**Consultation Response from KC,
Highways Development Management****2024/91477 Chutney Mahal, Folly Hall, Huddersfield, HD1 3PA****Erection of extensions and alterations to convert existing building into 32 student apartments****Date Responded: 29/08/24****Responding Officer: CNB****Responding Ref: K6-9NW/3**

GROUND FLOOR PLAN

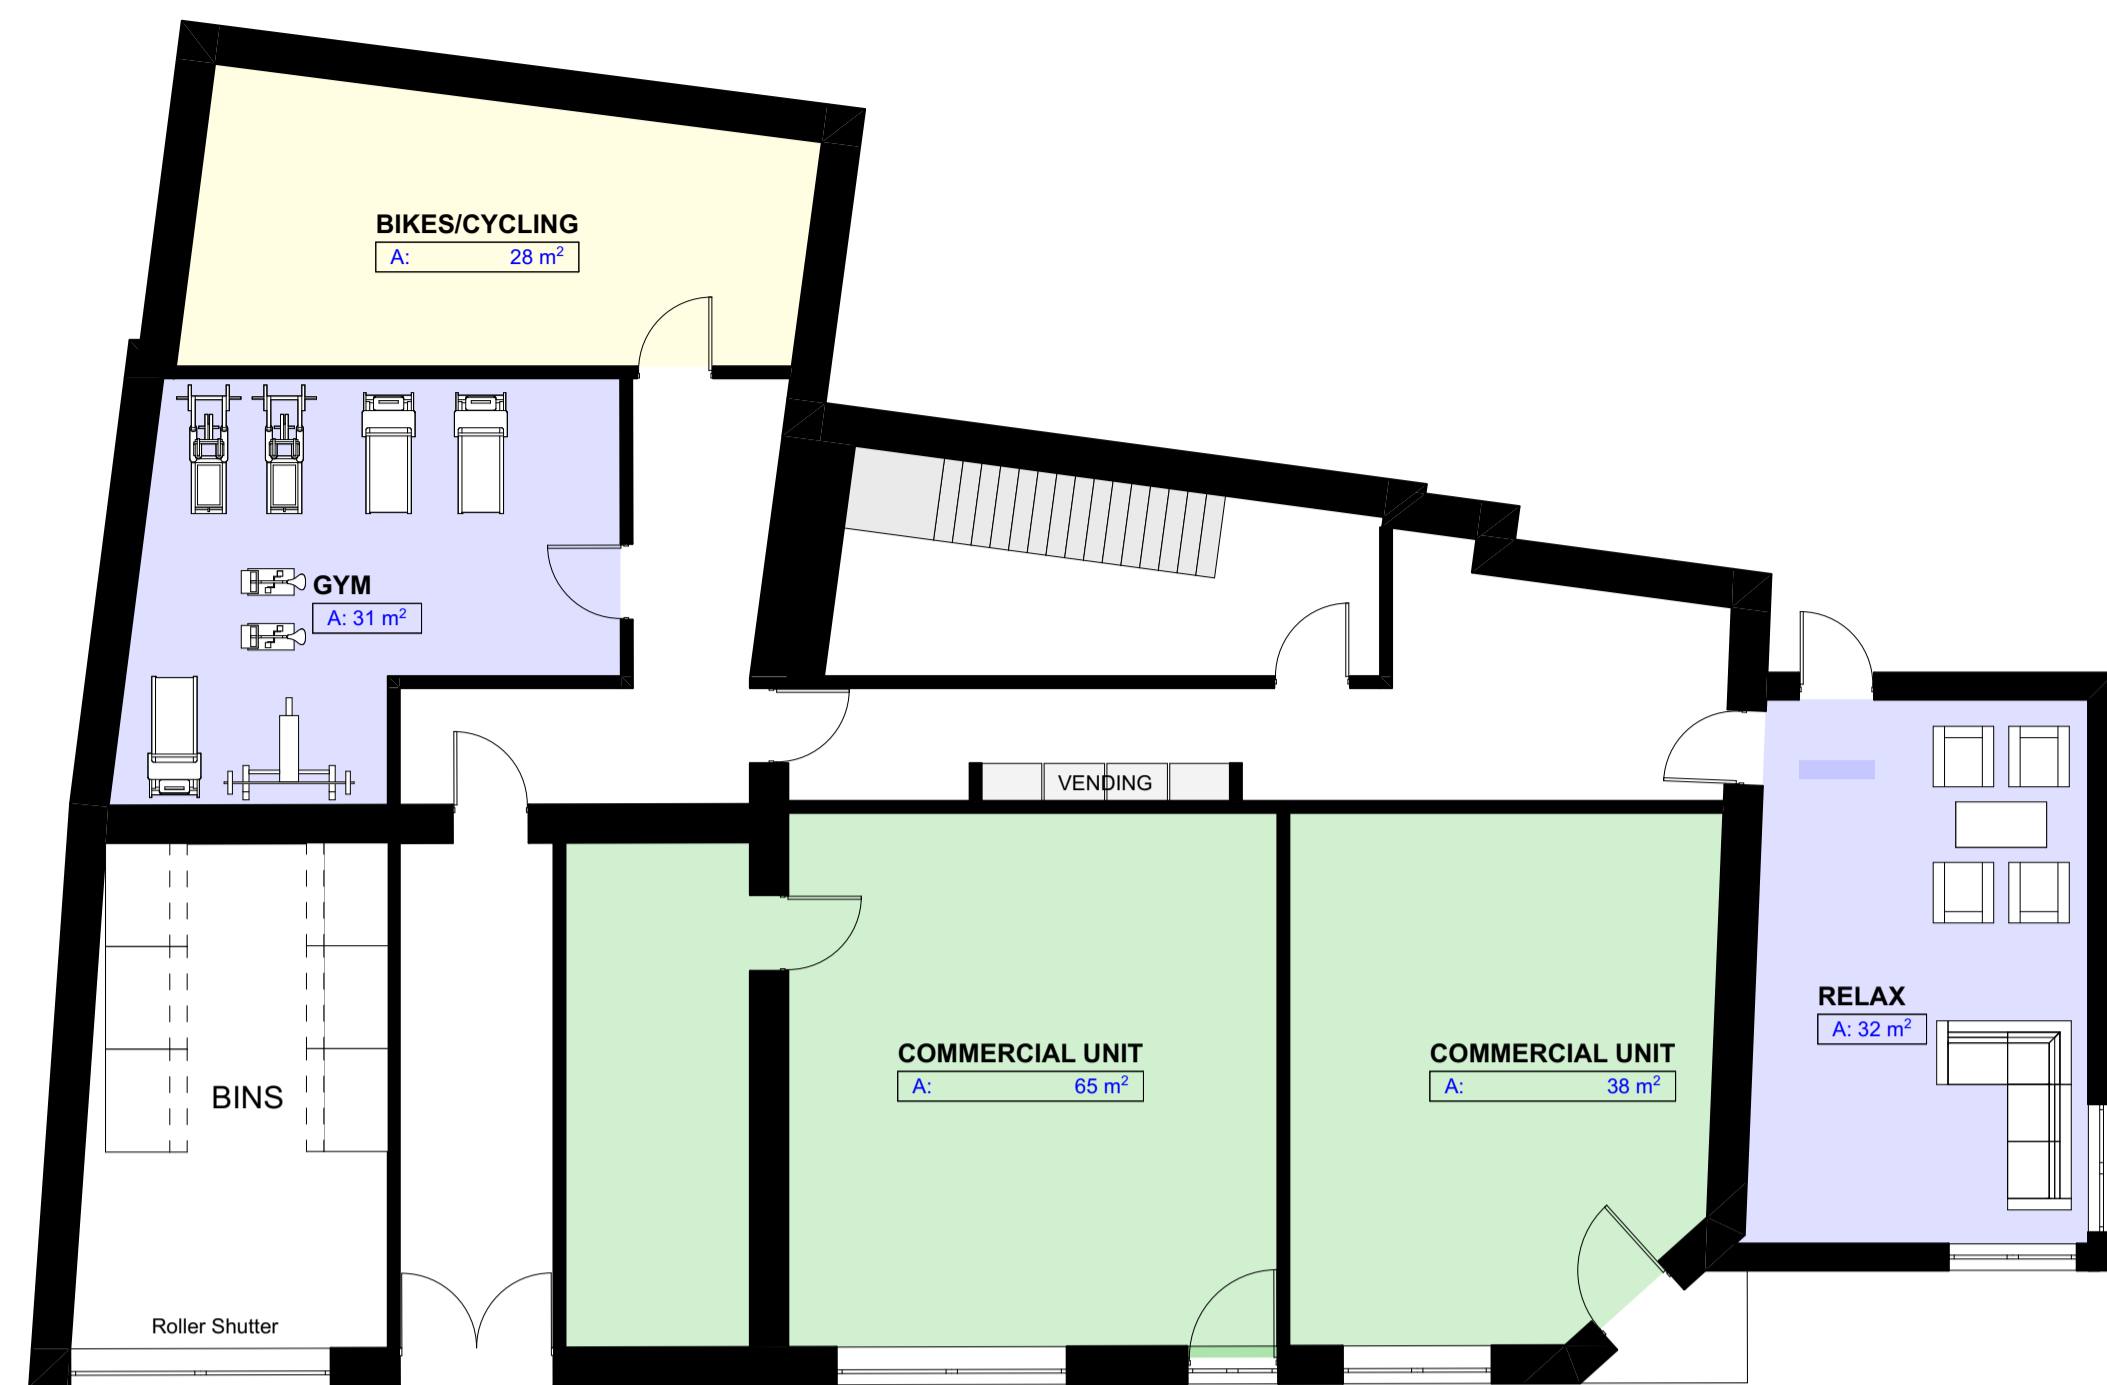
No details were provided relating to the servicing or waste collection from the premises. A bin store is indicated on drawing No FLH-PL-003 to the front of the building with a door opening out on to A616 Folly Hill, however this is located within the outer boundaries of the traffic signals adjacent to the southbound stop line on A616 and would be over the traffic detector loops. Any service vehicles waiting in this location are liable to cause an obstruction of the traffic signals, causing them to become inefficient, and a highway safety concern as queuing vehicles may wish to manoeuvre around them and will also obstruct the exit lane from the Broomfield Business Park. It is noted that the approach to the signals along A616 Folly Hill has waiting and loading restrictions, and these may impact upon servicing at the site.

We would need to see a suitable servicing management plan that explains how servicing to the development, including waste management, will be carried out without causing an obstruction to the signalised junction before we could support the current application.
